From: Peter Davey 
Sent: 04 June 2019 14:46
To: Anita Gardner
Subject: RE: AB/32/19/L - 13 Mount Pleasant Arundel BN18 9BD

client	project	drawing	date	drawn	drawing no	revision
Christine Fowler	New Doors / Windows at Dove Cottage, 13 Mount Pleasant Arundel, BN18 9BD	Proposed floor plan + elevations	Dec 18	pd	0273 / 102	B
			scale	CAD file name:		
			1:100, 1:200 @ A3

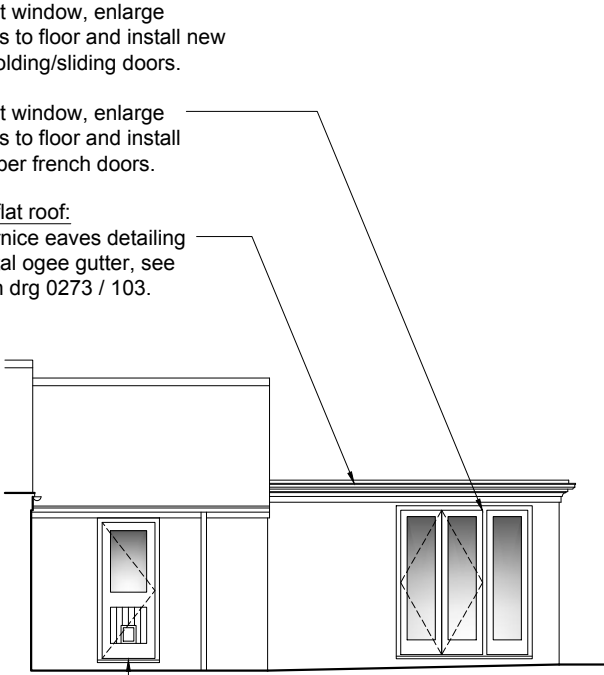
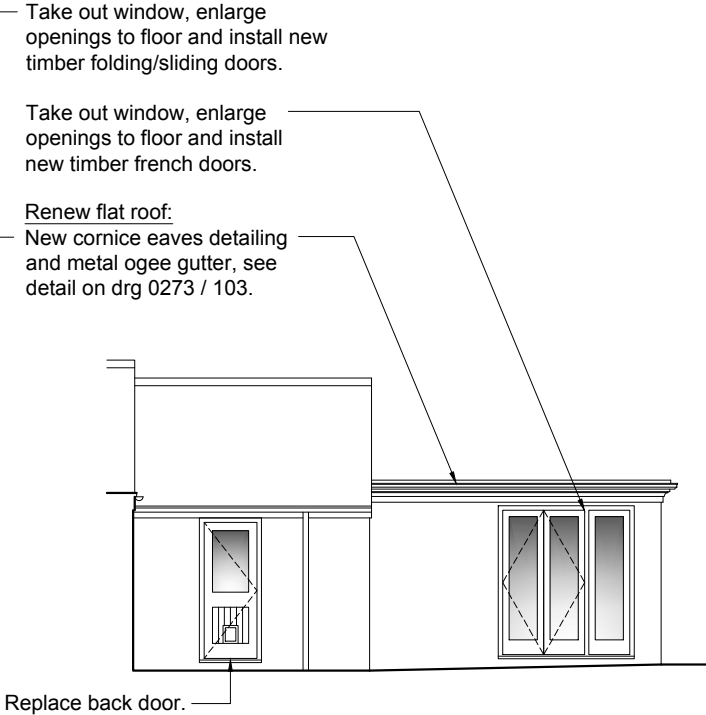
I note that two options have been provided for the low level lighting – please can it be confirmed which is proposed to be used?"

The alternative projecting light fitting has been omitted in favour of the original flush brick design.

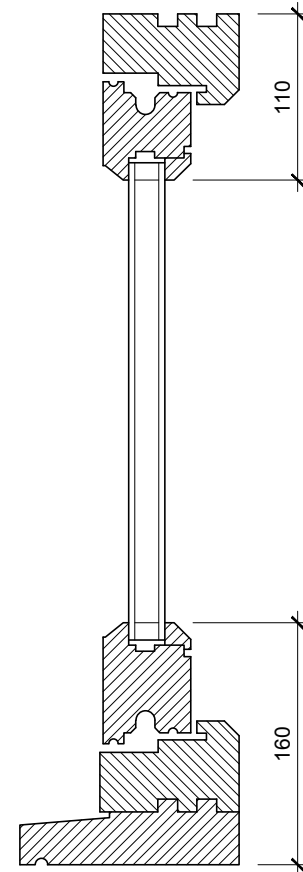
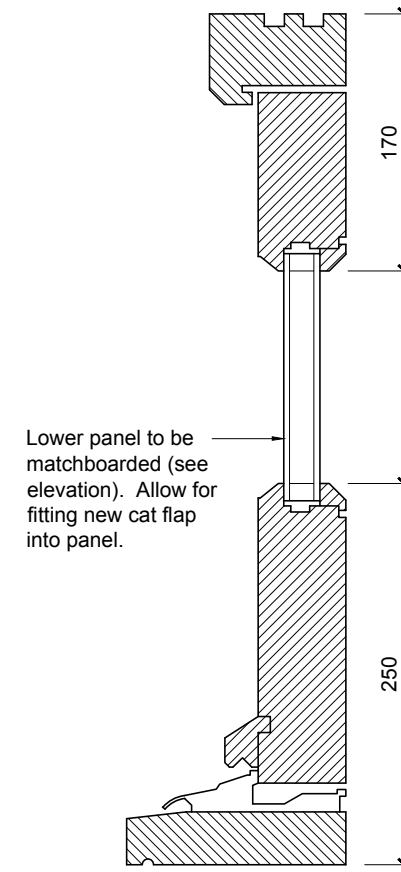
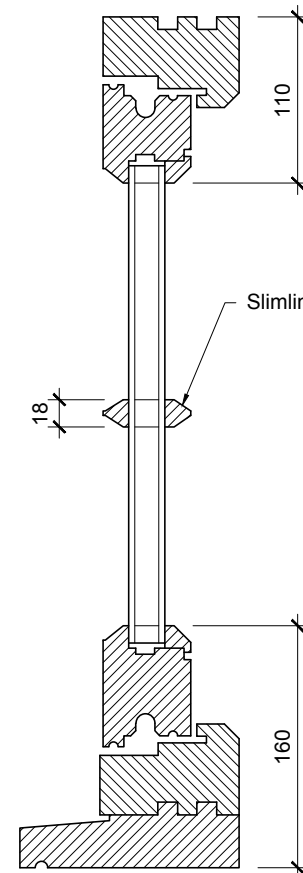
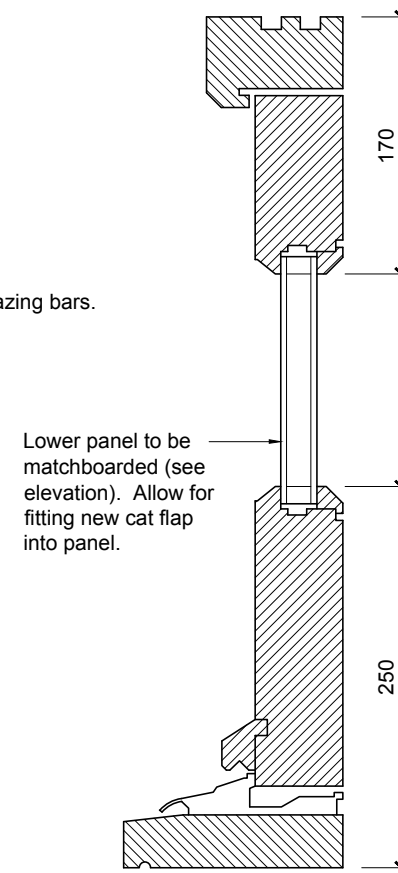
Further to my earlier e-mail I have now received the written comments of the Conservation Officer who has stated "it is not clear how the proposed glazing bars will appear? Will they be integral to the frame or merely placed on the glazing? Further, I note that the proposal is to use double glazed units. Whilst there might be justification for doing this as the loss of the crill windows is an improvement, it is not clear if the units will be of a standard design or the heritage equivalent. By this I mean the slimmer units. Further, no details are provided regarding the glazing bar for the windows; they should be integral to the frames and not merely added as though an afterthought. These details can be provided for by way of condition if minded to approve the application. the colour of the joinery should also match the existing.

I have today spoken to the Conservation officer. Without prejudice, he has requested confirmation of the precise glazing/glazing unit proposed. Is it possible this could be detailed on the cross section? If not further details could be conditioned? Please let me know how you wish to proceed.

The glazing bars are shaped in timber to match the beading. They protrude both sides of the glass with a spacer within the sealed unit to make them indistinguishable from structural bars. If structural glazing bars had been used, it would significantly reduce thermal performance. Also by using double glazed sealed units, a structural glazing bar would have to be much heavier in profile which would not be in keeping. This proposal allows the use of slimline bars to match the original.
